Application No: M/99/21/PL
Site Address: Guernsey Farm Yapton Road Middleton-On-Sea PO22 6DY
Description of works: Change of use of existing farm shop and agricultural buildings to light industrial (Class E(g)) and storage and distribution use (Class B8). This site is in CIL zone 5 (Zero Rated) as other development.

Thank you for your internet representation made on 9th August 2021 which has been recorded as an objection with the comments as follows:

Figure 2.1. Accident Study Area

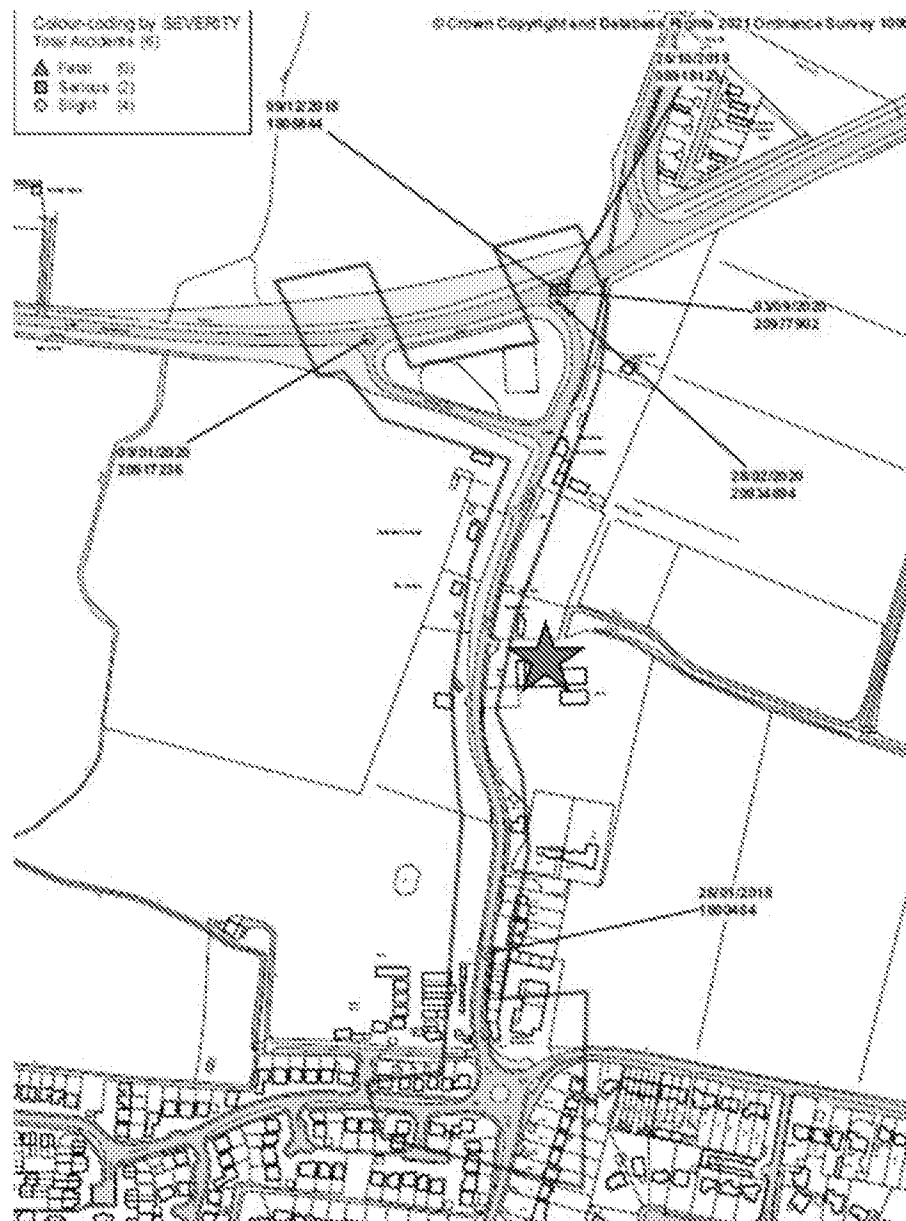
I wish to object to planning application primarily because the accident data review in the Transport Statement by RGP Consulting Engineers (RGP 20/5650/TS1 dated May 2021) is a sham. At Para 2.4.10 the report concludes that based upon the evidence used "it is not considered that there are any underlying road safety issues relating to the condition or layout of the highway (at the Yapton Road/Worms Lane (A259) Junction (Comet Corner) that would be exacerbated by the development proposals". The report highlights six accidents stating that all were due to driver error, stating in Para 2.4.9 that there were no highway/hazard layout issues. The fact is that almost all vehicle accidents are due to "driver error/misjudgements", and Comet corner is a lethal junction because of the weight of traffic on the A259. Near misses and dangerous driving practices are a daily occurrence, exacerbated by frustration, particularly for drivers turning right on the Yapton Road onto the A259, and left from Worms Lane. In addition to the Police data, a more valid check of the junction's safety and suitability to handle even more traffic would have been to video record traffic movements over an extended period and to count the number of near accidents. Local residents are only too aware of how dangerous this junction is, and the inevitable increase in use by vehicles associated with the proposed industrial units will only add to the problem. I object to this plan; it will further degrade the already minimal safety margins at Comet Corner; its approval by Arun District Council without a more detailed investigation would be tantamount to negligence.
